26 Northorpe Lane
Mirfield
West Yorkshire
WF14 0QJ

9 August 2022

Application Number 2021/91914
Proposed Development at the back of 28 Northorpe Lane

Proposed Site Layout

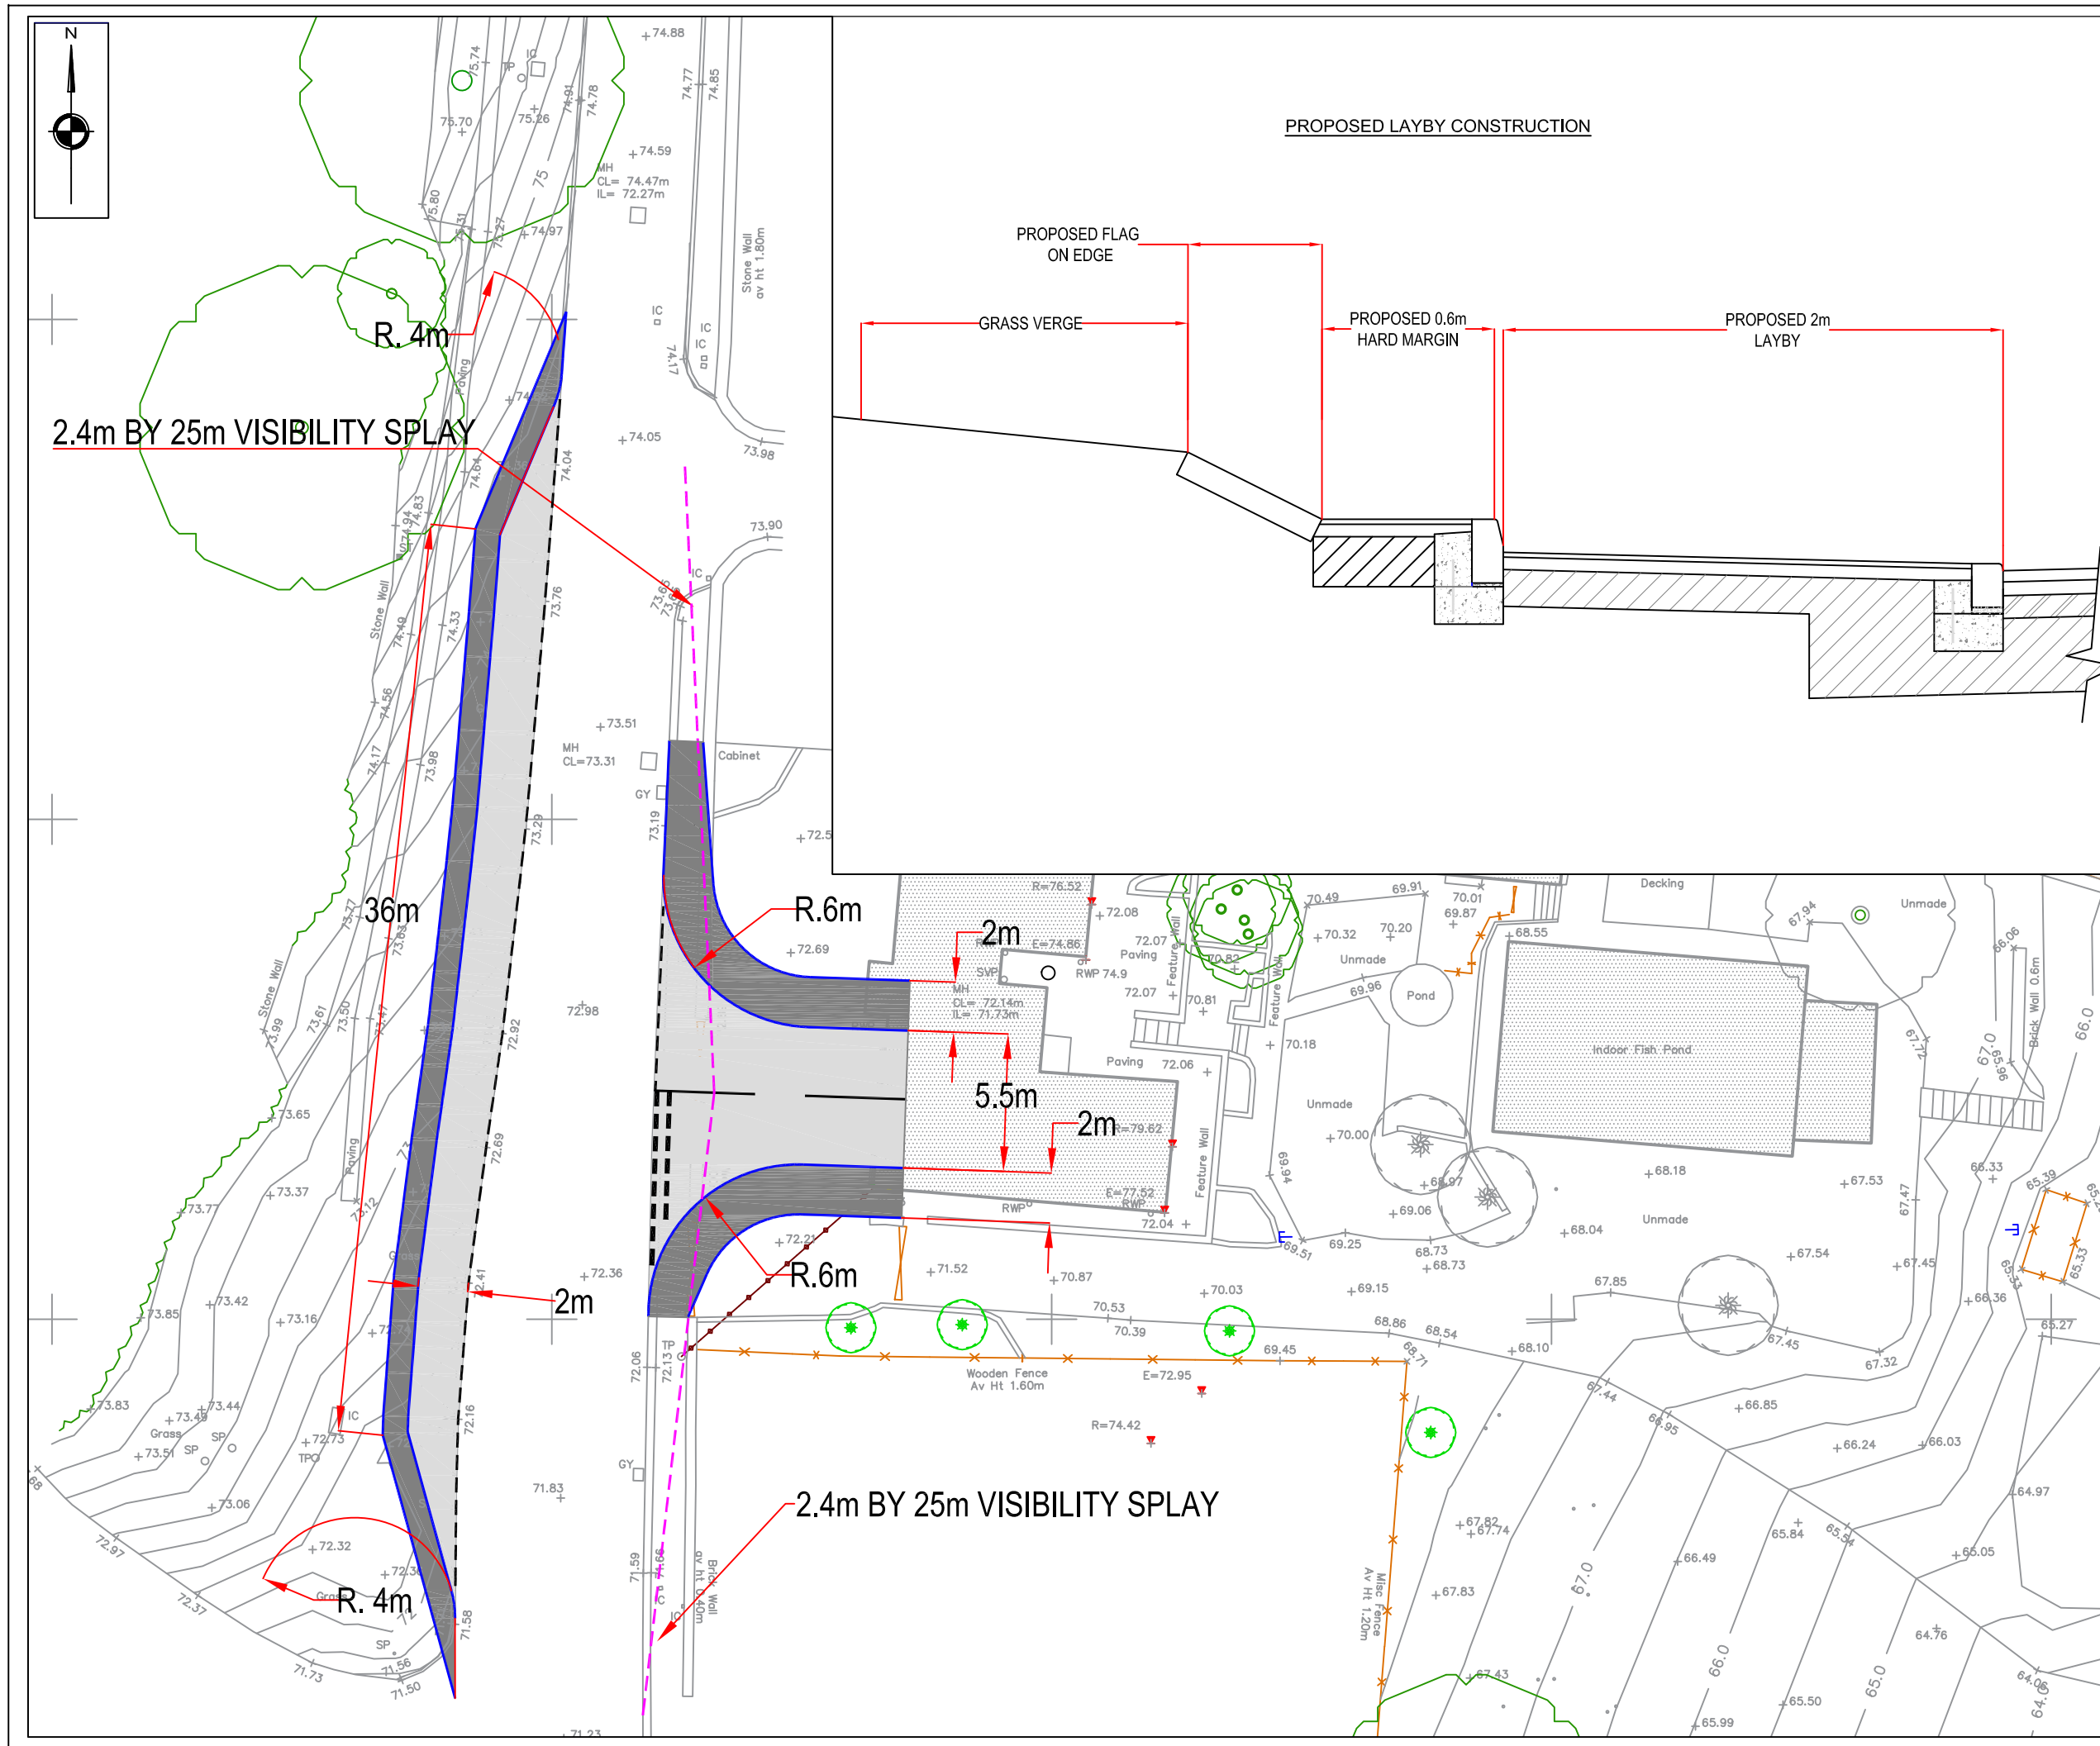
Still there is no site plan available about the grass verge and the proposed lay-bye on Northorpe Lane. This is a crucial part of the development and as yet no final plan is available to the public. Various plans on line have different features. One has vegetation, then the next one has not, but there are no references to the length of the lay-bye, but a suggestion that it might be two metres 600 cms. wide. Northorpe Hall say they have all the documentation to claim ownership of the verge and as yet Kirklees have supplied no evidence in this respect, apart from guess work which would not stand up to any examination in the County Court.

Surely before any planning permission can be approved a completed set of plans should be available for the housing site and the verge, so that a considered judgement can be made. Without which the development is open to questionable practice. I understand that no highway engineer has contacted the Hall about the proposed lay-by. Without widening the road, it is unimaginable how thousands of tons of infill can be transported up the narrow lane.

In the plans that have been published several matters have arisen from poor planning. Firstly – road safety issues. Most of the roads have visibility splays apart from a right angled turn to the left that has none. Surely an ambulance, refuge vehicle, Fire Engine, Yorkshire Water vehicle need visual clearance at this corner. There is no social housing on the site and I thought that this was a priority on Kirklees Applications. On the plan it mentions a green corridor, which I suggest is the railway banking that belongs to Haighs (have they been asked?), and has always been there, so it is not part of the planning process. Against Kirklees Policy is a pump drainage system to take sewerage upwards onto the existing pipes on Northorpe Lane, a recipe for disaster.
